East Anglia ONE North and East Anglia TWO Offshore Windfarms

Applicants' Comments on SASES' Deadline 5 Submissions

Applicant: East Anglia TWO and East Anglia ONE North Limited
Document Reference: ExA.AS-22.D6.V1
SPR Reference: EA1N_EA2-DWF-ENV-REP-IBR-001251

Date: 24th February 2021
Revision: Version 01
Author: Royal HaskoningDHV

Figure: 29.37e
Viewpoint 5: Public Right of Way, near Moor Farm

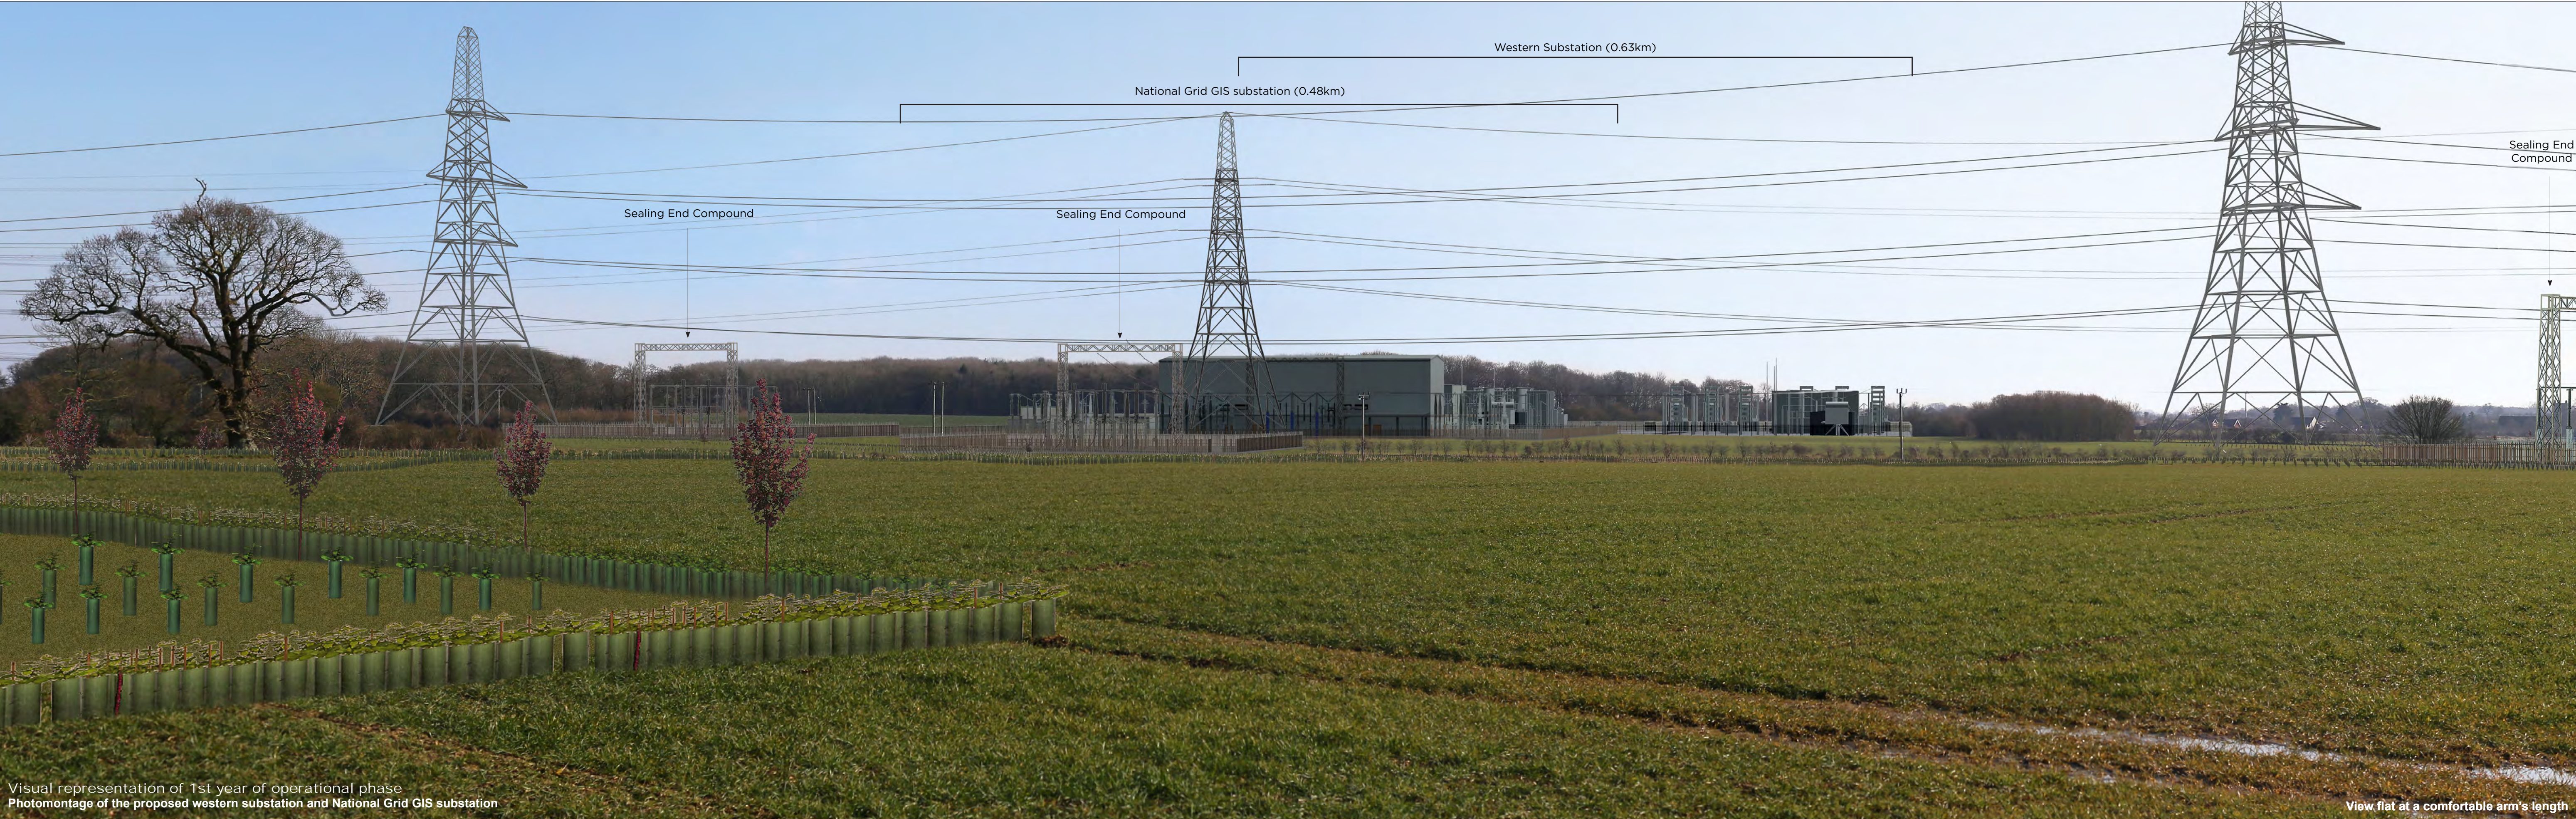
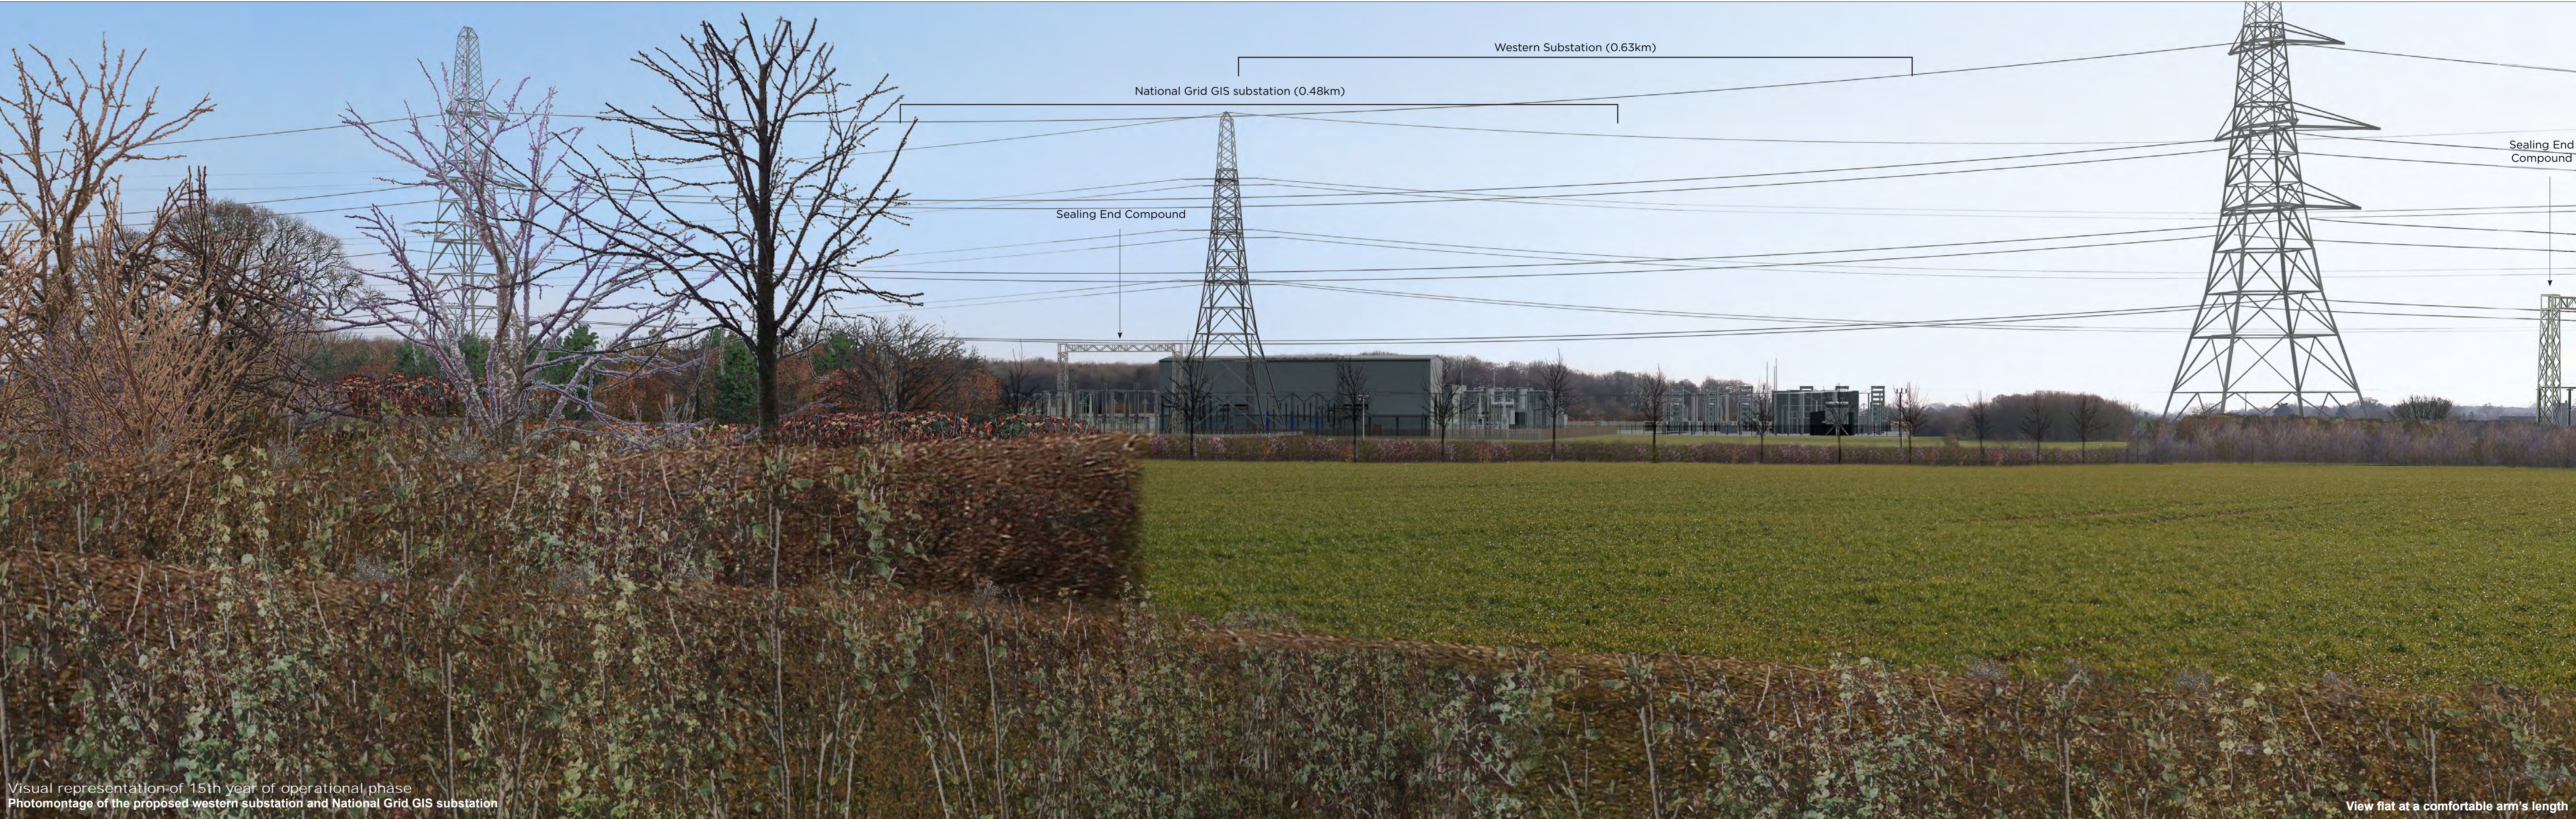
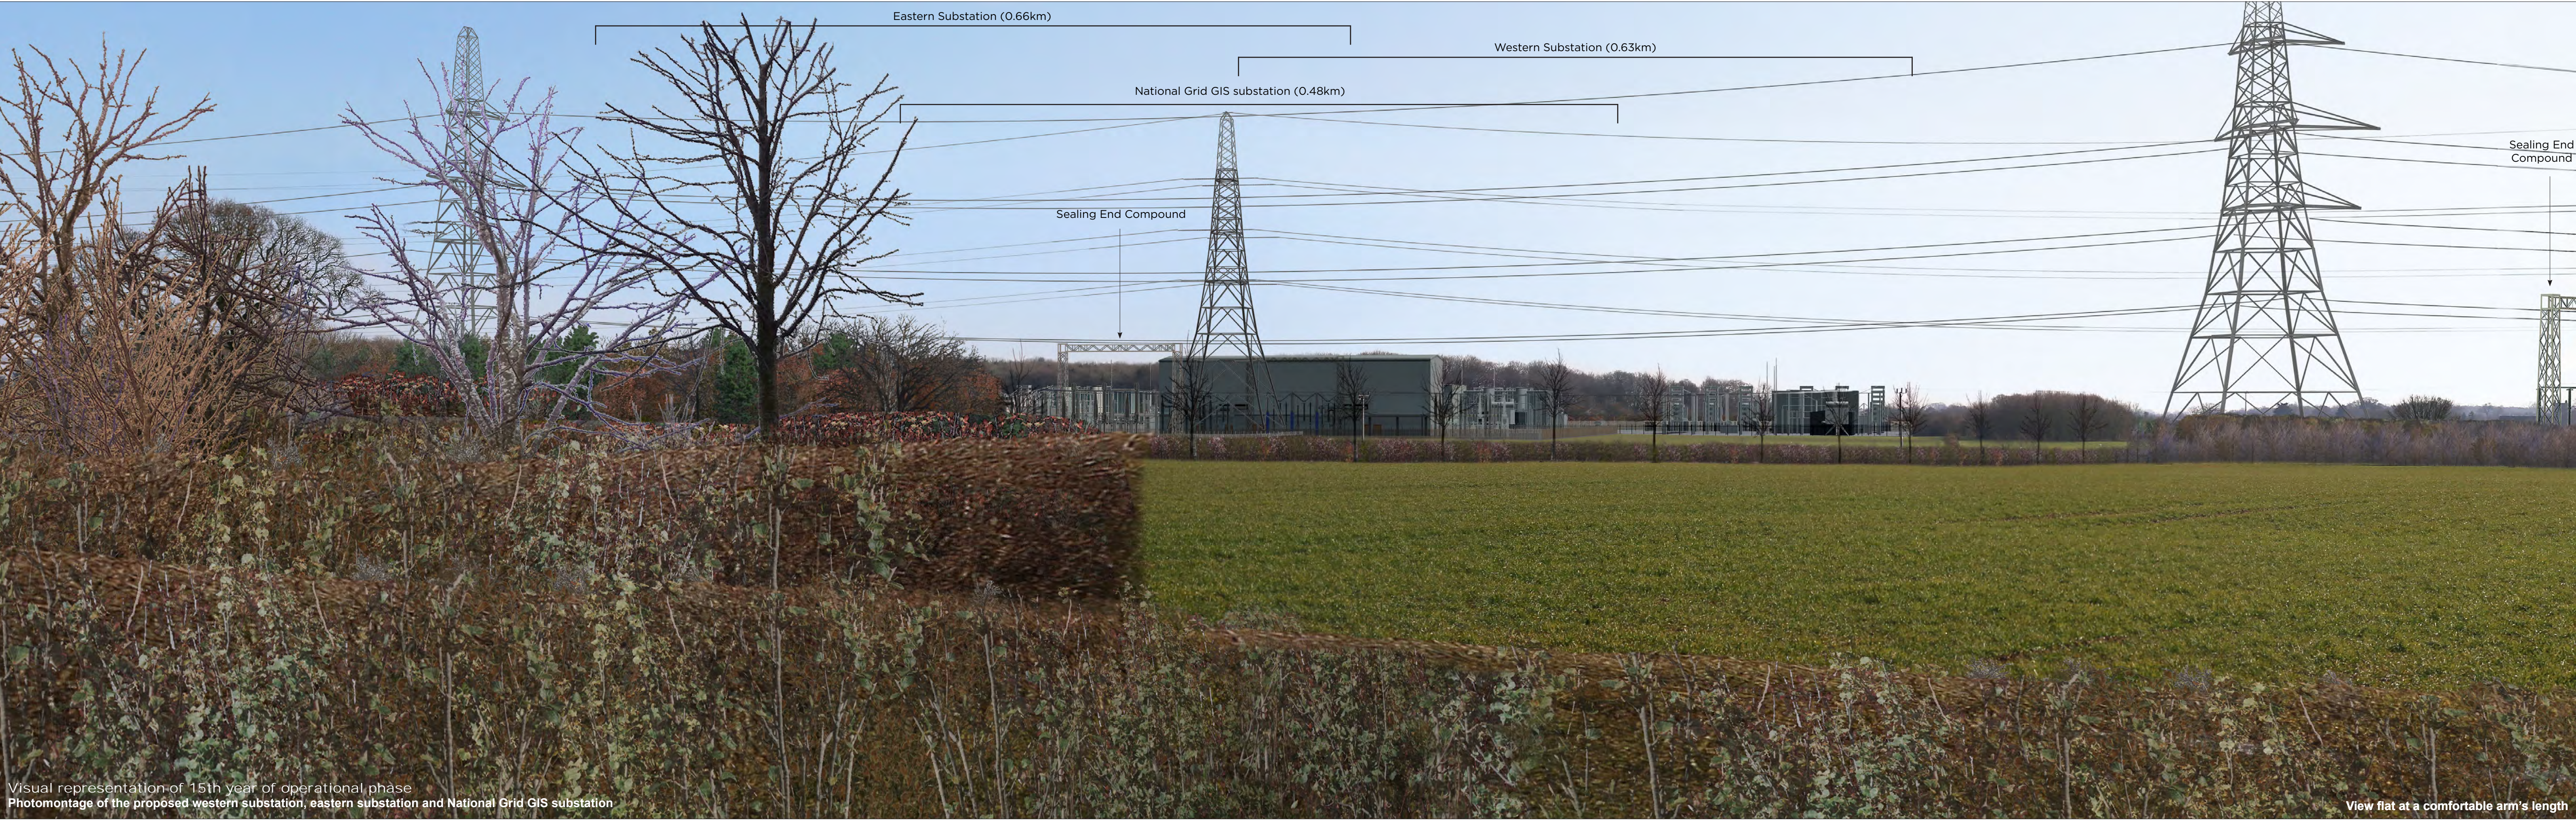
36	<p>The revised photomontages from Vp 5 which is presented on two frames now illustrates more clearly the impact of the development on the distinctive character of the landscape to the north of the village in which the presence of the church makes a significant contribution. The revised photomontages from Vp 5 illustrates how the landscape to the north of the substations will be severed from the village and there will be a total loss of the current relationship between this landscape and the village. The Landscape and Visual Impact Assessment Addendum accepts that the changes made during the</p>	<p>The Applicants note the visual effects shown in Viewpoint 5 and the presence of the substation infrastructure in the view towards Friston village. The Applicants note that the majority of the substations are not directly within the view towards Friston village, but primarily to the east of it, with the sealing end compound and re-aligned pylon forming the main elements in the view towards the village, through which it is possible still to see St Mary's Church. The Applicants would note that the openness of the wider view over the landscape would be retained, even in the presence of the substation</p>

ID	Written Representation	Applicants' Comments
	<p>examination process will not reduce the visual impact from this viewpoint or other viewpoints to the north. From Vp 5 the effect will remain significant, adverse and permanent.</p>	<p>infrastructure. The landscape proposals will also reduce the visual impact of the substation infrastructure and re-instated hedgerows and tree lines will contribute towards a network of re-instated historic field boundaries in the view. The Applicants note and agree that the residual effect on people experiencing the view from Viewpoint 5 will remain significant.</p>
37	<p>In Applicants' Comments on SASES' Deadline 1 Submissions the applicants lists in a number of places (e.g. Page 148) the factors that they consider have reduced the visual impact of the development. Not listed is the rearrangement of elements within the substations. As set out in EN010077-003522-sases deadline 4 Submission - Appendix 1 to Comments on Applicants' Deadline 3 Submissions this accounts for some of the reduction in visual intrusion between the original photomontages and the revised photomontages in Vps 2 and 9. As the layout of the substations is not currently a controlled element of the DCO any improvement as a result of the rearrangement of equipment cannot be relied upon. If a specific arrangement is being relied upon to reduce visual intrusiveness there needs to be a specific requirement with regard to the layout.</p>	<p>The final layout of the onshore substations will be confirmed as part of the detailed design phase, which is undertaken post consent. Where possible, and in accordance with electrical safety requirements, the Applicants will explore with the supply chain further opportunities to reduce the impacts.</p>
